Date: 22-Jul-2026
Our Ref: 2026/91607

**TOWN AND COUNTRY PLANNING ACT 1990
TOWN AND COUNTRY PLANNING (GENERAL PERMITTED DEVELOPMENT)
(ENGLAND) ORDER 2015 – SCHEDULE 2, PART 1, CLASS A.1 (g)
AT: 36, Moor Park Avenue, Beaumont Park, Huddersfield, HD4 7AL
Prior notification for single storey rear extension**

The proposal is for erection of single storey rear extension. The extension projects 4m beyond the rear wall of the original dwellinghouse. The maximum height of the extension is 3.5m, the height of the eaves of the extension is 2.5m

DRAWING TITLE
Proposed Plans

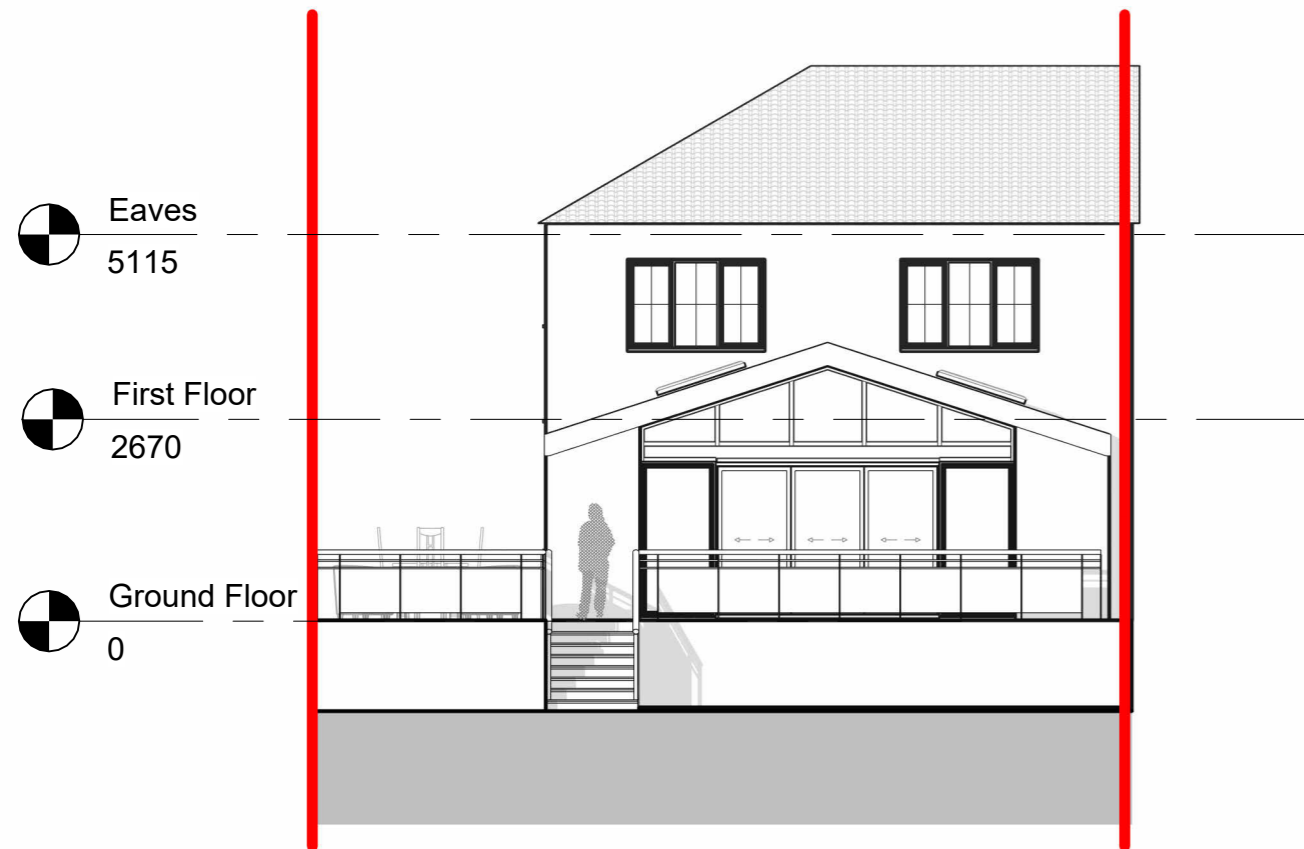
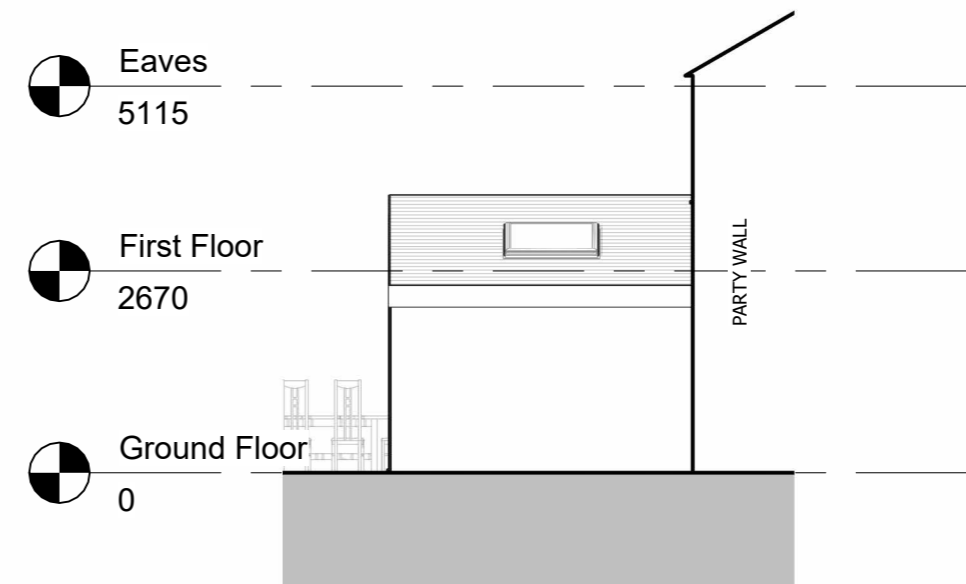
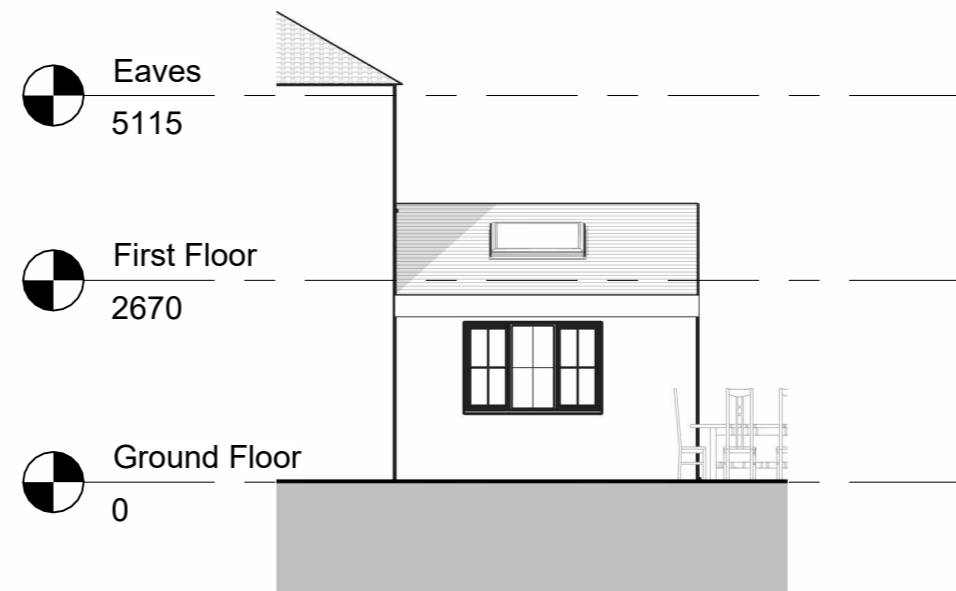
By virtue of its size, scale, projection, proximity to the shared boundary and massing the proposed development would cause an unacceptable degree of harm to the amenity of the occupiers of the adjacent property by reason of leading to overbearingness on the shared boundary, loss of light and overshadowing. The development would cause an unacceptable level of harm to the amenity of neighbouring occupiers contrary to policy LP24 of the Kirklees Local Plan, principles within the Council's adopted House Extensions and Alterations SPD and policies within Chapter 12 of the NPPF.
